TfNSW Reference: SYD20/00077/01 and SYD15/01390/20  
DPI&E Reference: SSD 10397 Stage 2 and SSD 7348 Mod 3

**MODIFICATION TO CONCEPT PLAN AND STAGE 2 (CONSTRUCTION OF BUILDING 2B) - OAKDALE WEST INDUSTRIAL ESTATE- ERSKINE PARK**

TfNSW has reviewed the modification application and Stage 2 application, and provides the following comments for your consideration in the determination of this application:

Figure 4: Approved Intersection Layouts – 2026 Modelling Scenario

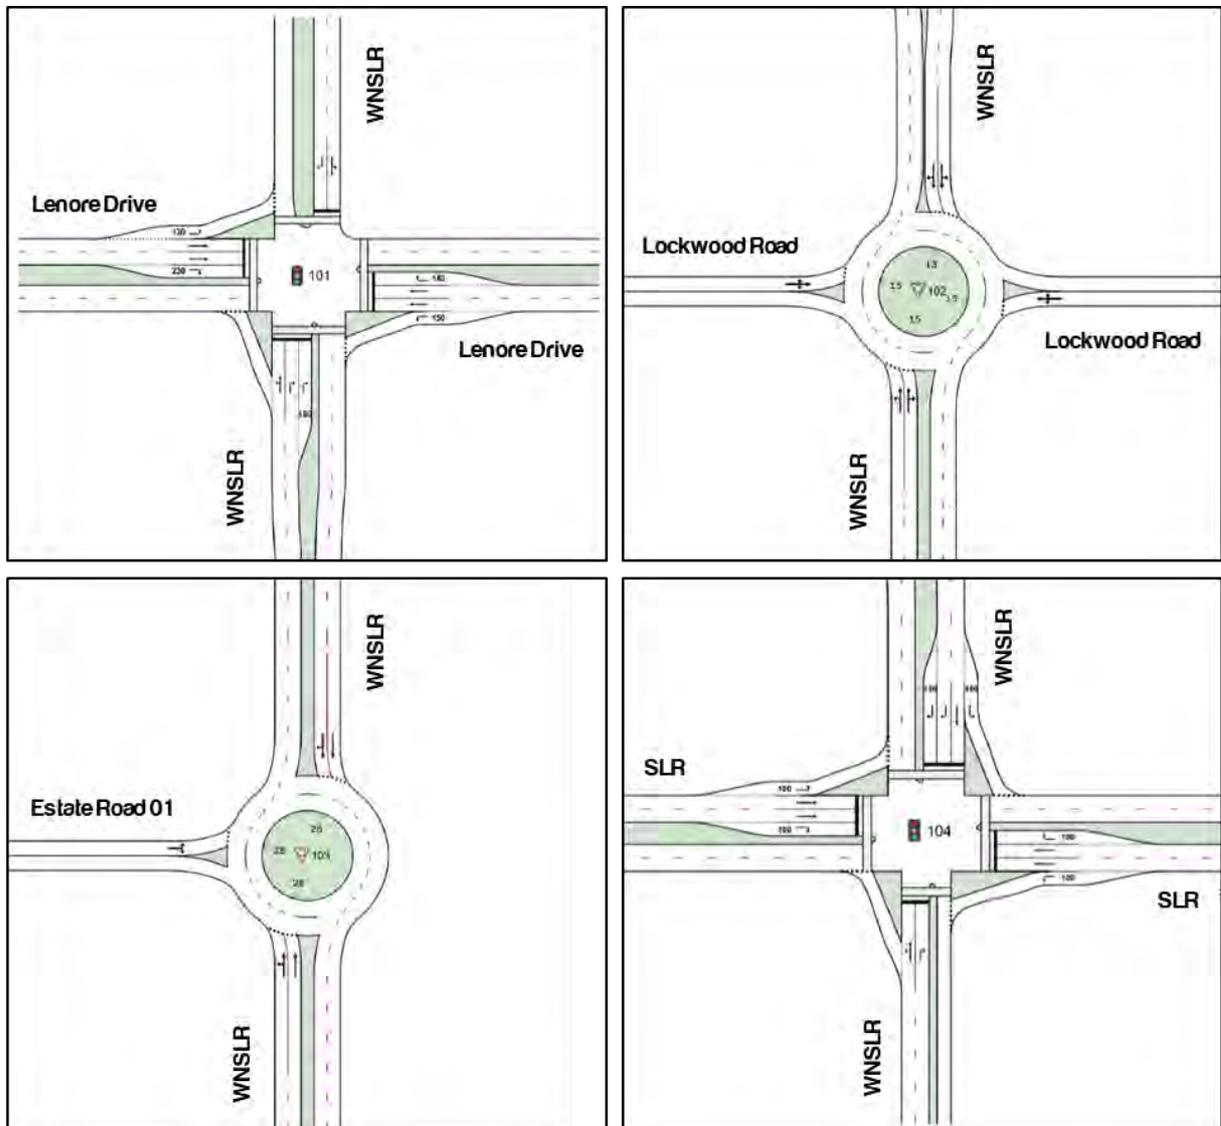
It is not clear in the submitted Traffic Report whether the left and right turn bays in the interim intersection design for the WNSLR/Lenore Drive intersection can accommodate the additional traffic movements.

As such, TfNSW requests a copy of the electronic SIDRA files and output summaries for the 2026 interim peak and non-peak scenarios for the WNSLR/Lenore Drive intersection for further review and comment.
